REPORT UPDATE

Application No: BE/151/11/

Location: Land South of Shripney Garden Caravan Park, Shripney Lane Bognor Regis

Description: Extension to existing caravan park to provide 12no. additional mobile homes, associated parking area, formation of access and construction of electrical intake housing - Amendment to application BE/42/10

SHRIPNEY GARDEN CARAVAN PARK, SHRIPNEY LANE, SHRIPNEY
Proposals 01 B
Nov 2011

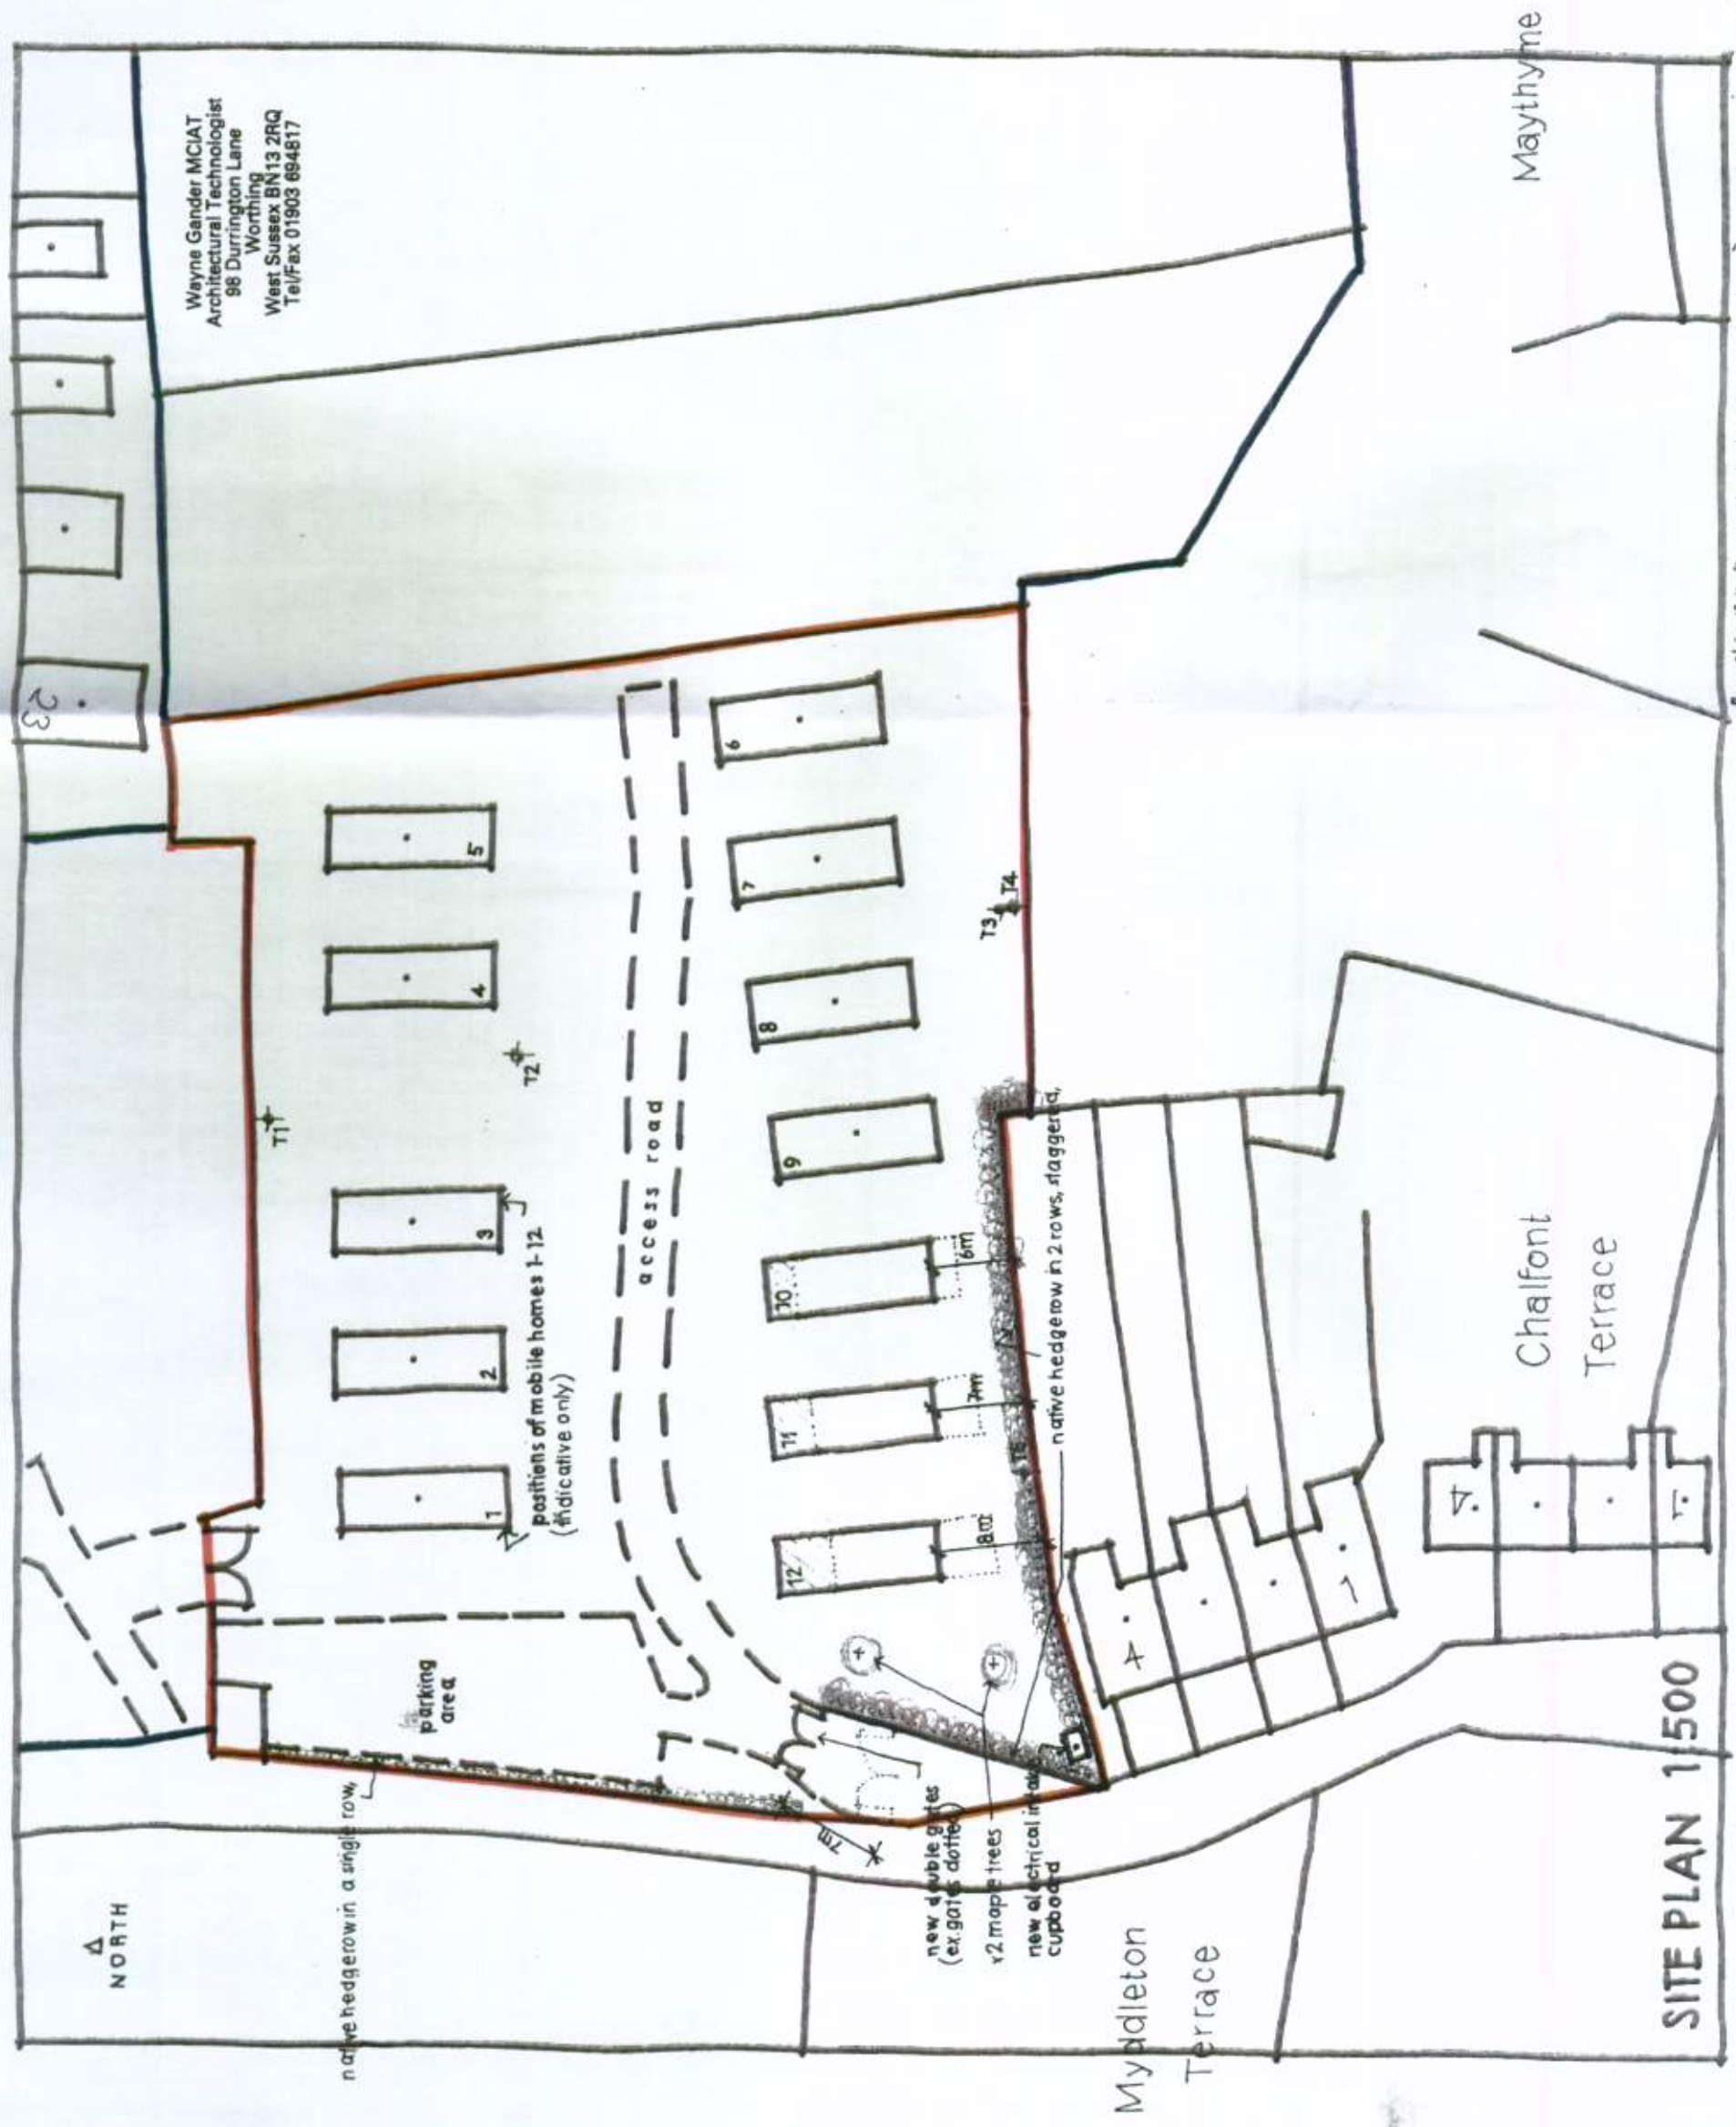
The extension is 30m not 17m. An internal access road is not shown. Planning History BE/38/08 has been omitted which shows the Inspectors criticism. Report omits Parish Council statement that the applicant stated all work had been approved by Arun District Council. The Inspector identified the site as Grade 1 or 2 agricultural land. There is an agricultural use on the site opposite. Environmental Health commented that Fire and Rescue Services should comment on the new access. Economic Development Section were not consulted re: BE/42/10, where is their response? The Inspector stated that the area was environmentally sensitive and that the proposal would have an urbanising effect on the character of the countryside. The Market Needs Assessment did not state other sites in the built up area that could accommodate the need. The GPDO is applicable to sites not requiring a licence and the site requires a licence and beyond the scope of the Caravan Site and Control of Development Act 1960. The access has moved closer to the Myddleton Terrace. The caravans do not need to move to accommodate trees. The boundary with the lane should be a double row of native hedgerow. If conditions were in accordance with Circular 11/95 why were they not enforced?

Noted. Letter from applicant's agent stating that the proposed hedgerow on the southern boundary will be difficult to maintain and it would be slow growing. It is understood that the neighbour also did not want the hedging. Therefore request the Condition 3 be amended to standard conditions.

* Noted. The size was measured on site by an Enforcement Officer and is shown on the submitted plan. The conclusion describes the history and Inspectors decision of BE/38/08. Cannot comment on third party discussion when no details submitted. Under application BE/41/95 the Inspector dismissed the appeal on the grounds that the land was Grade I - 2 Agricultural land, however since that time and before BE/38/08 Government policy changed the classification and the Inspector for BE/38/08 raised no objection regarding this. Fire and Rescue is part of the licence and the applicant was advised of Environmental Health response in the officers report. The Economic Development Section were consulted regarding BE/42/10 but made no comments. The Inspectors comment referred specifically to - in the absence of a justification - that he would have to conclude the proposal had an urbanising effect. The justification was submitted with BE/42/10 Market Needs Assessment. An explanation of planning controls concerning caravan sites was included within the conclusion of the Committee Report. Site layout is controlled by the site licence. This application resulted from Enforcement Investigations, under planning legislation changes can be made to approvals provided they seek retrospective approval such as in this case.
